# KIRKLEES METROPOLITAN COUNCIL INVESTMENT & REGENERATION SERVICE

### DELEGATED DECISION TO DETERMINE PLANNING APPLICATIONS

| Reference No:         | <b>2024/62/90732/W</b>                                                        |
| Description:          | Erection of single storey rear extension and loft conversion with rear dormer |

2nd Floor
1 : 50

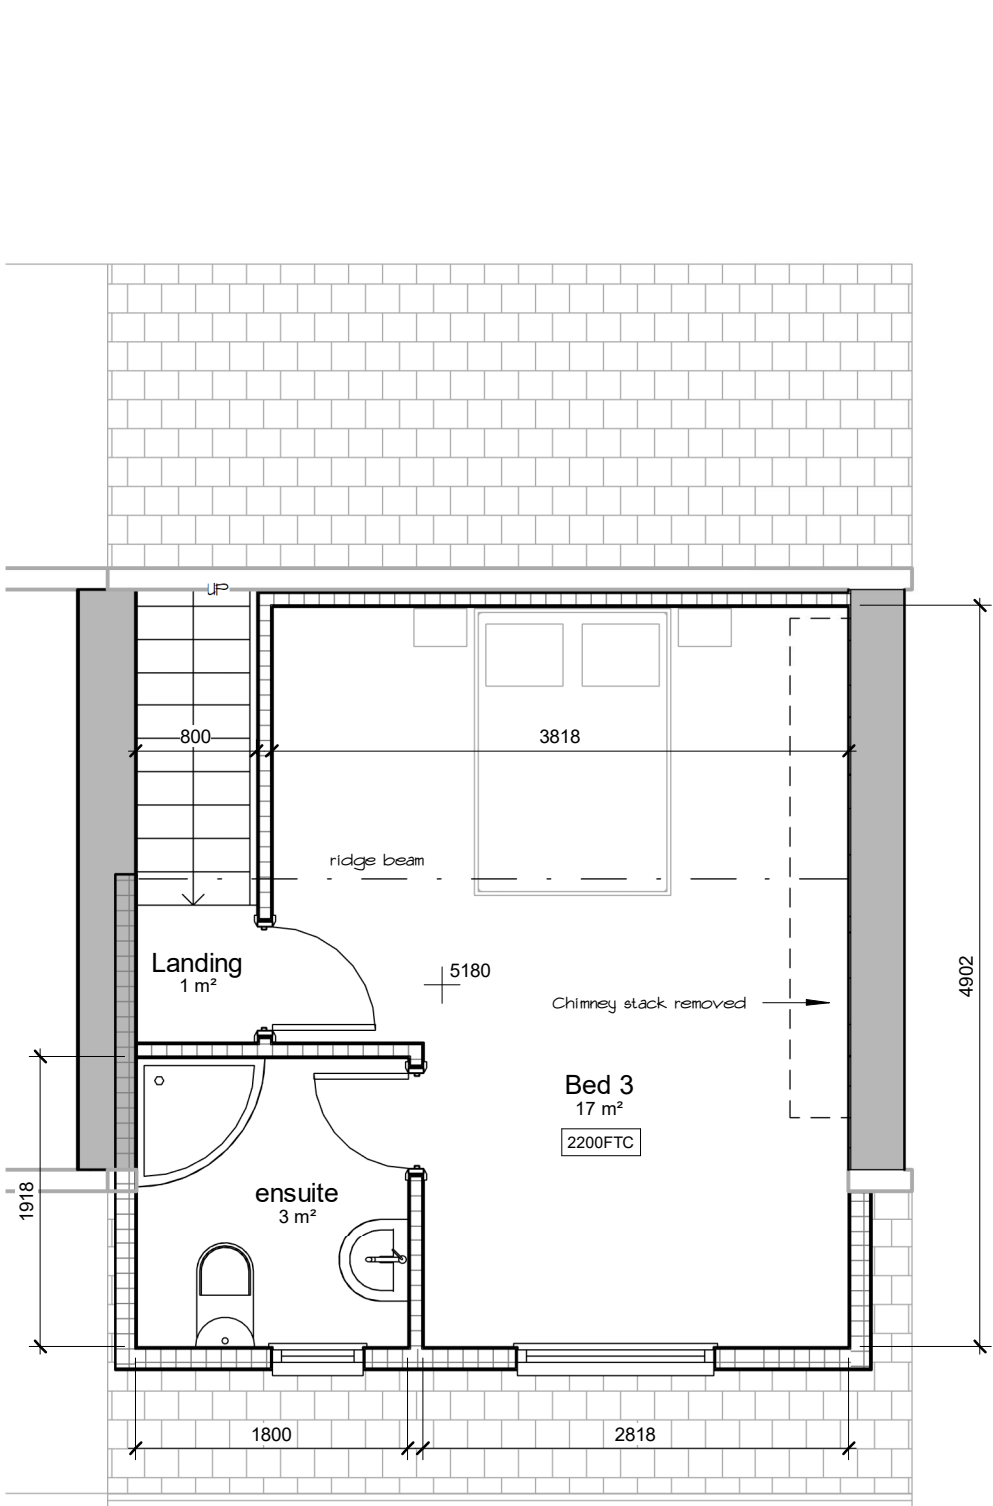
- ~2.4 metre projection
- ~4.7 metre width
- ~2.5 metre eave height
- ~3 metre total height

- ~5 metre width
- ~2 metre height
- ~3.2 metre front projection

The chimney stack would be removed as part of the works.

| retain a gap of at least 1 metre from a property boundary, such as a wall, fence or hedge                                                               | The extension would be constructed along north-west facing boundary. | The rear extension at the application property would lie flush with the rear outrigger of adjoined neighbour, No 68. Although against SPD guidelines, there would be no visual benefit of setting the extension off the boundary by 1 metre and is acceptable in this case. |

| not dominate the roof or project above the ridge of the house                                            | The dormer would not project above the ridge of the house. It takes up most of the roof, but no more than the pd fallback |  |

The extension would not project beyond the existing ground floor outrigger of this dwelling, therefore the extension would not be detrimental with regard to overshadowing/overbearing. The dormer would overlook the rear garden of this property and would not present any greater impact to privacy than that already exists.

Site Plan
1 : 200

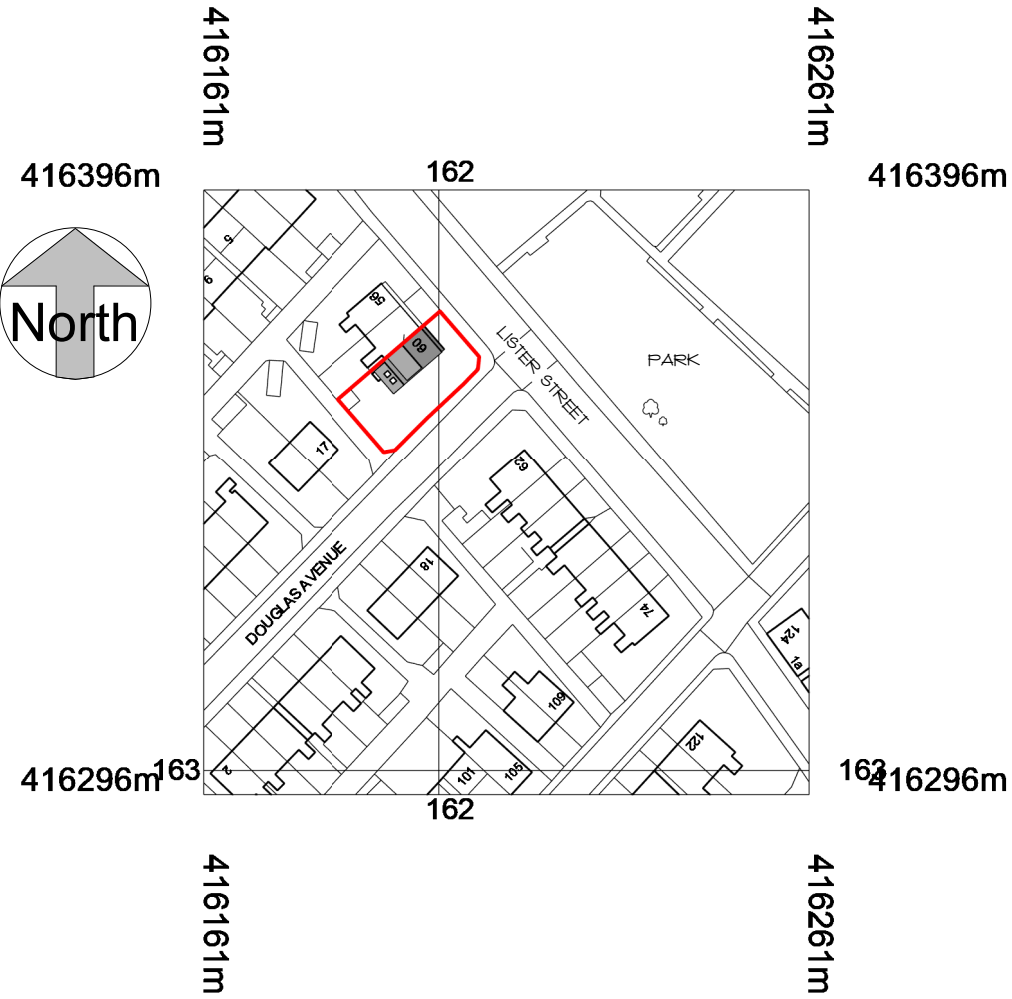
| Remaining garden space of application property                       | <ul style="list-style-type: none"> <li>• KDP 7 of the SPD</li> <li>• Policy LP24 Design (b) and (c)</li> <li>• Chapter 12 of the NPPF</li> </ul>      | Over half the garden space would be retained. | ✓ |

|  | <ul style="list-style-type: none"> <li>• Policy LP24 Design (d) (iv)</li> <li>• Chapter 12 of the NPPF</li> </ul> | sufficient space within the red line boundary. |  |
